DRB Application No.: 09DRB-70313 Project # 1008005
 Project Name: LONGFIELD ADDITION
 Agent: JACK'S HIGH COUNTRY Phone No.: _____

DEVELOPMENT REVIEW BOARD--SPEED MEMO

4. ~~Project# 1008005~~
09DRB-70313 MINOR - PRELIMINARY/
FINAL PLAT APPROVAL
- JACKS HIGH COUNTRY INC agent(s) for CLASSIC EMPORIUM III LLC request(s) the above action(s) for all or a portion of Block(s) 1, Tract(s) B & C, **LONGFIELD ADDITION** zoned C-2, located on CENTRAL AVE NE BETWEEN EUBANK NE AND ELIZBETH NE containing approximately 2.2728 acre(s). (L-21) **THE PRELIMINARY/FINAL PLAT WAS APPROVED WITH FINAL SIGN OFF DELEGATED TO TRANSPORTATION FOR DIMENSIONAL EXHIBIT, MAINTENANCE AND BENEFICIARIES AND 36 FT WIDE PRIVATE ACCESS EASEMENT AND TO PLANNING TO CLARIFY UTILITY EASMENT AND AGIS DXF FILE.**

PLAT OF TRACT B-1 AND C-1 LONGFIELD ADDITION

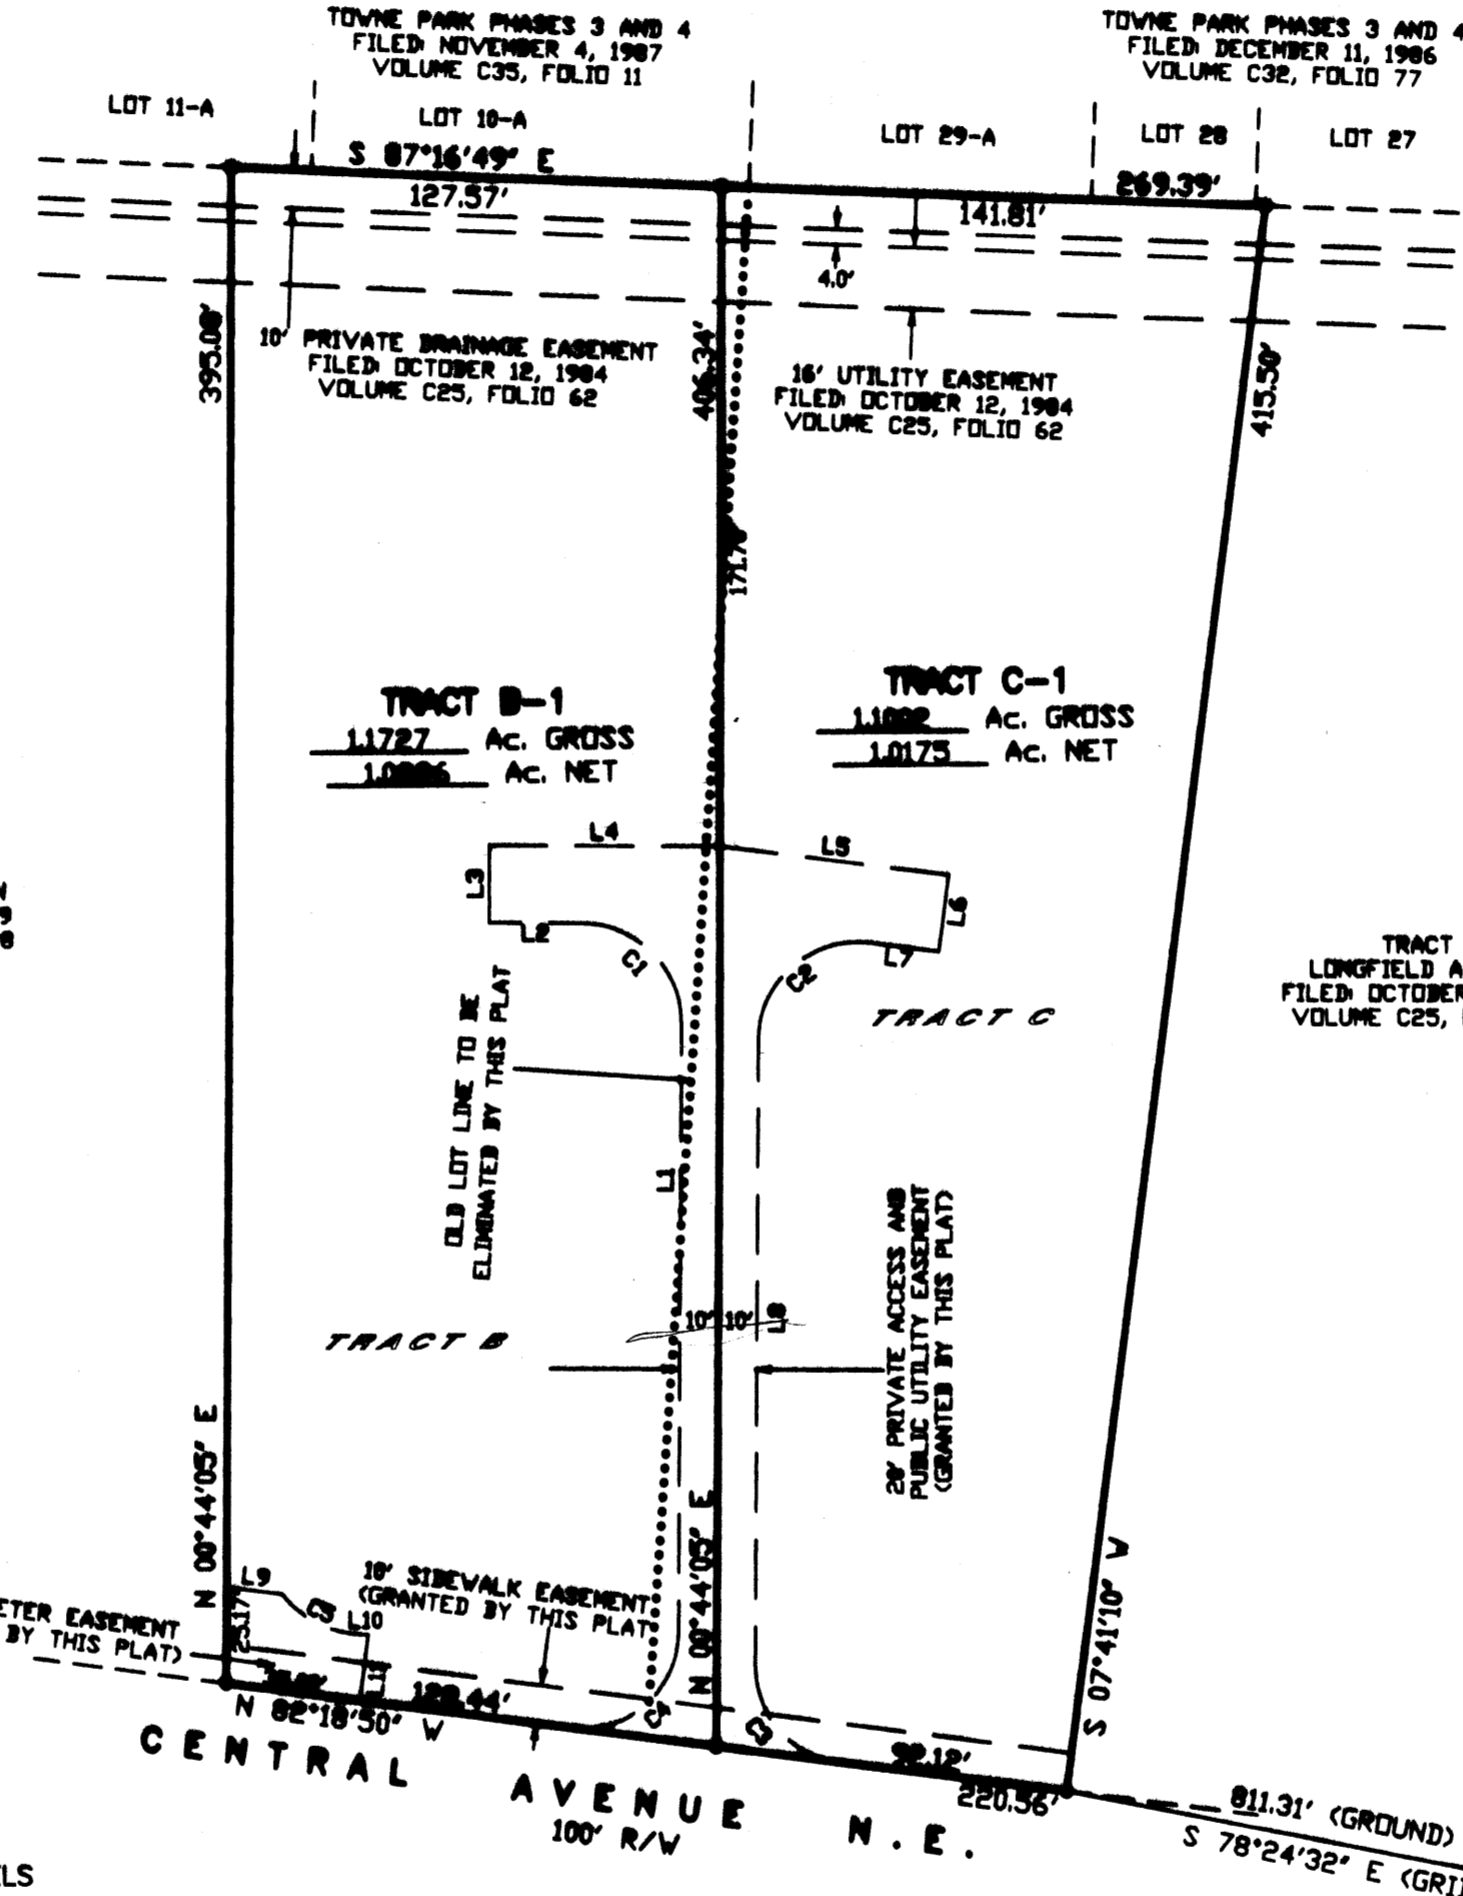
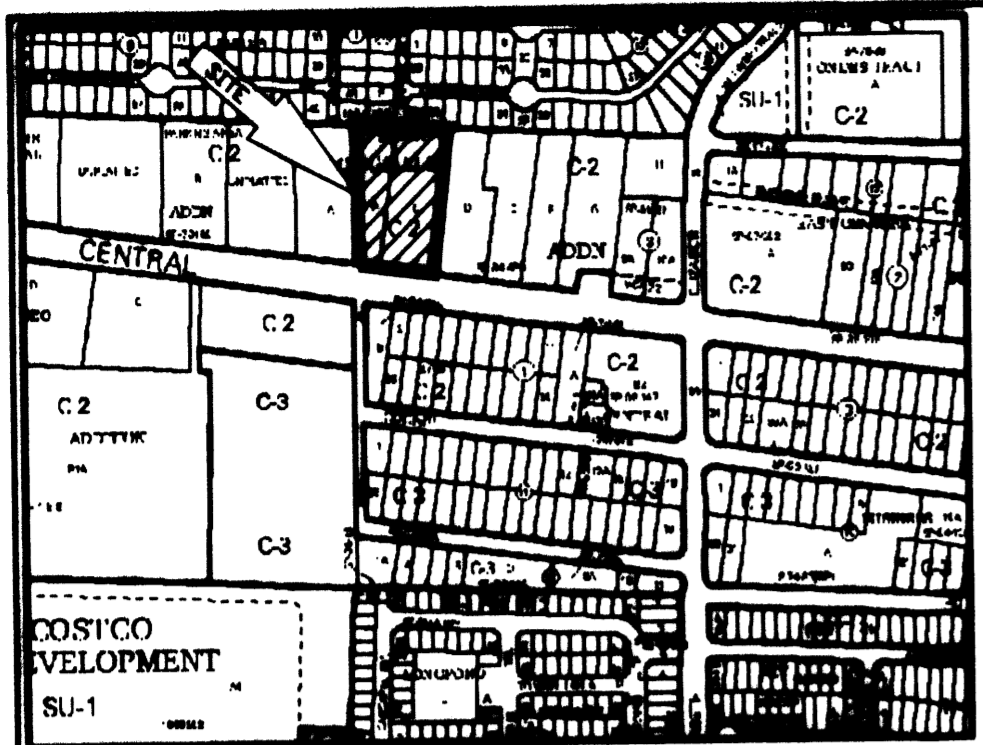
TRANSPORTATION: - address comments

PLANNING (Last to sign): - clarify 'Utility' Fee mod
